COUNTY OF HARNETT LAND USE APPLICATION

**Re: Status of Improvement Permit Application #08-S-19824
Persimmon Hill Lt 18**

Lot #18 Persimmon Hill
08-500-19824

Wm. Kent Pierce Inv.  
Lot #18 Persimmon Hill  
 210 Old Field Loop

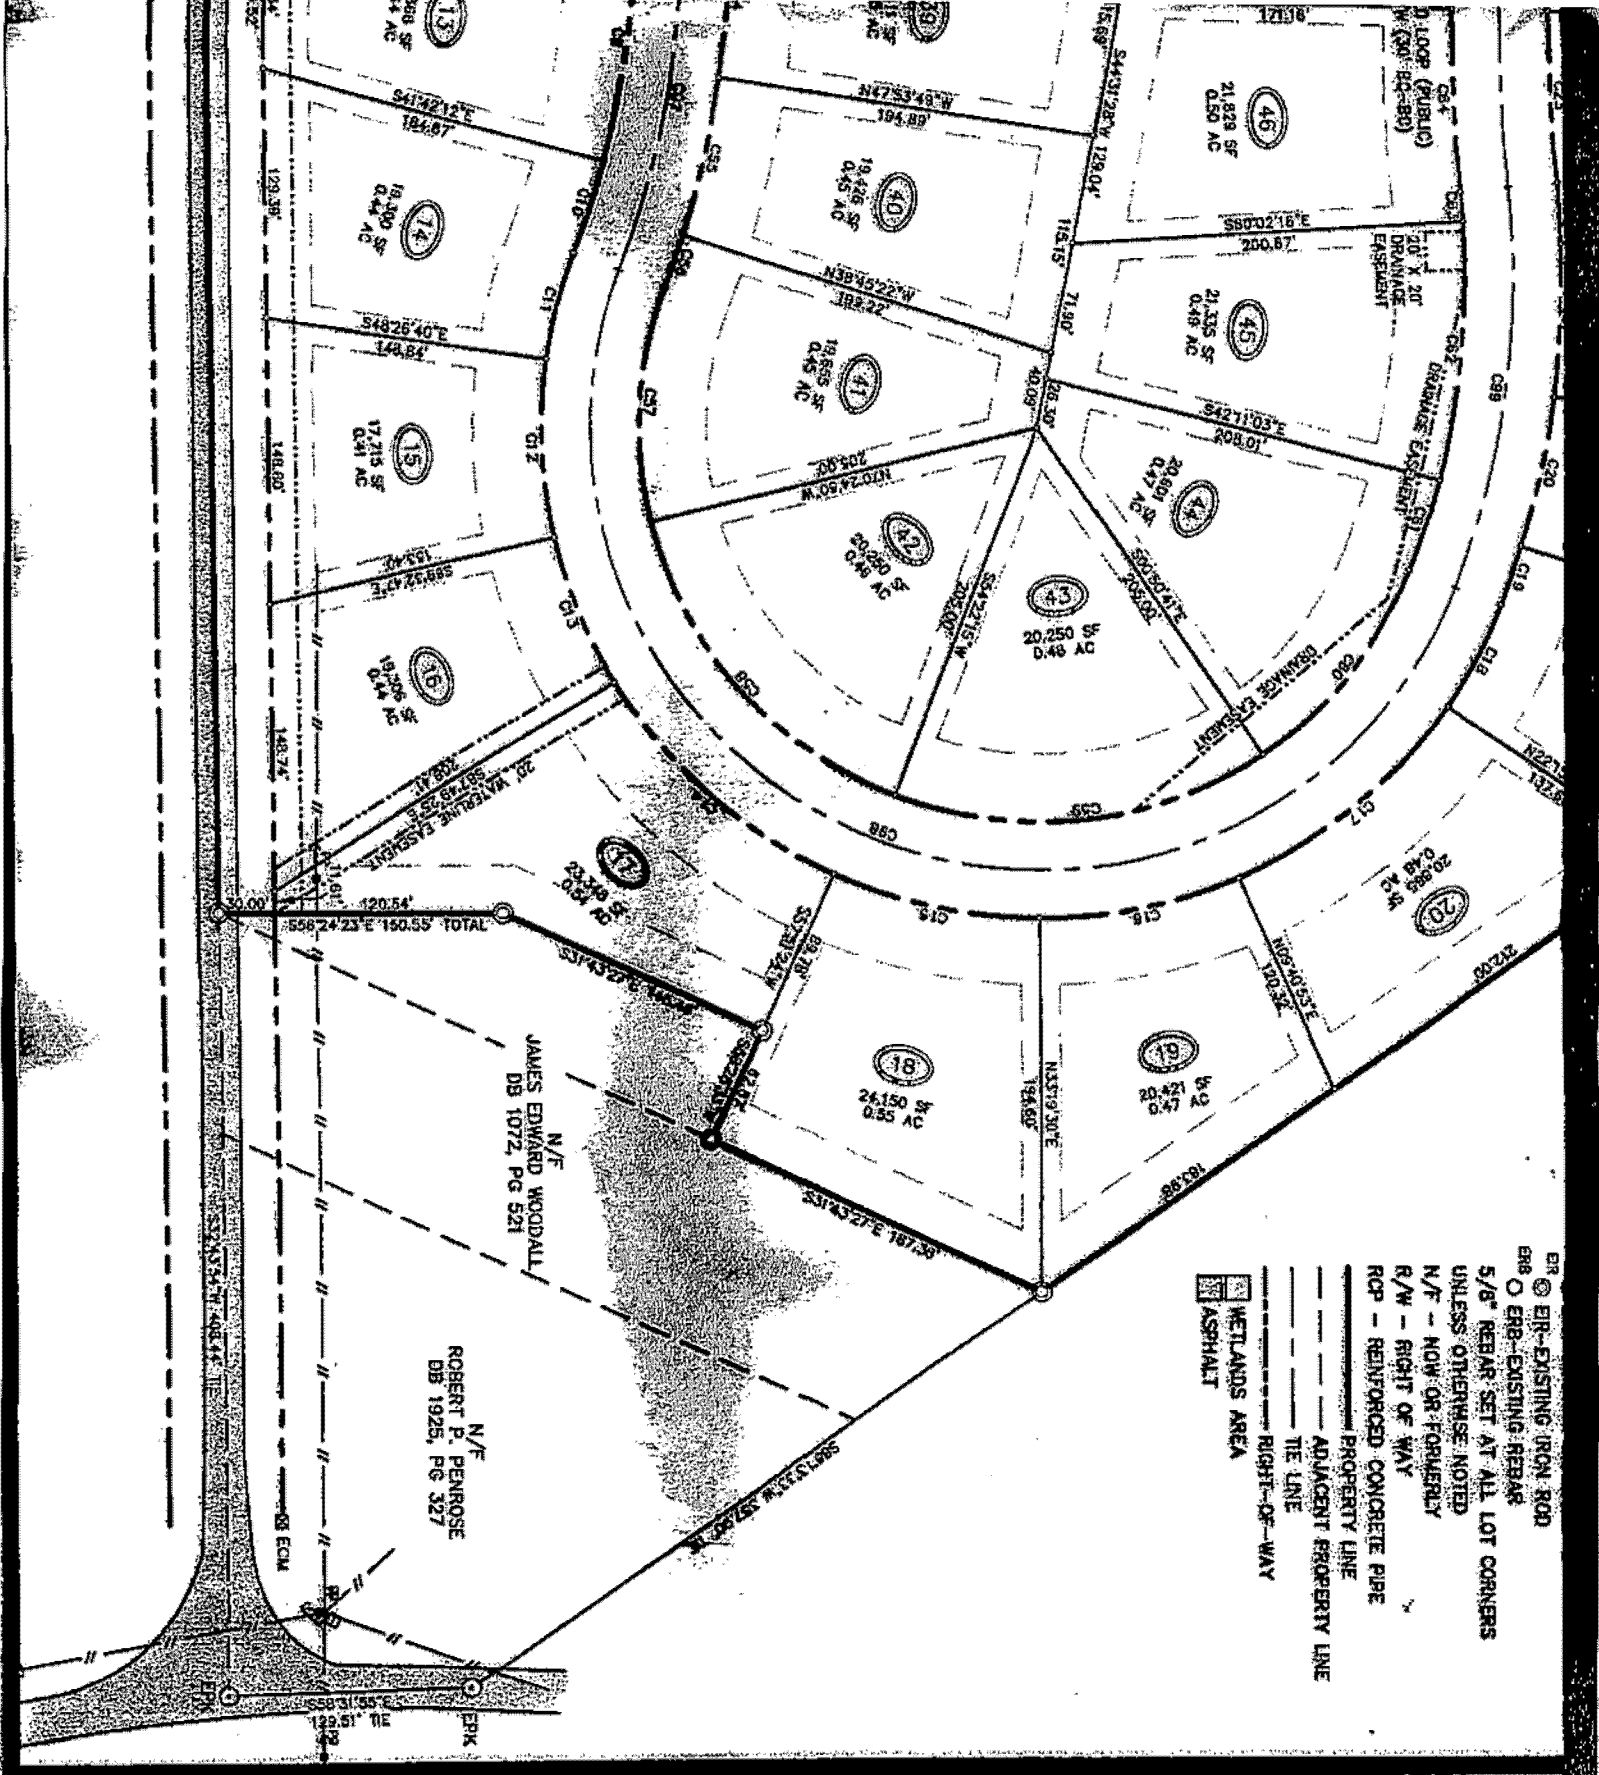
- 1. Property lines/corners not marked or labeled
- 2. House corners not marked or labeled
- 3. Directions not clear to property
- 4. Property needs brush or vegetation removed
- 5. Backhoe pits required
- 6. Other - Move home as shown and submit new plot plan to Central Permitting and reconfirm.
(Please note change in garage and drive location).
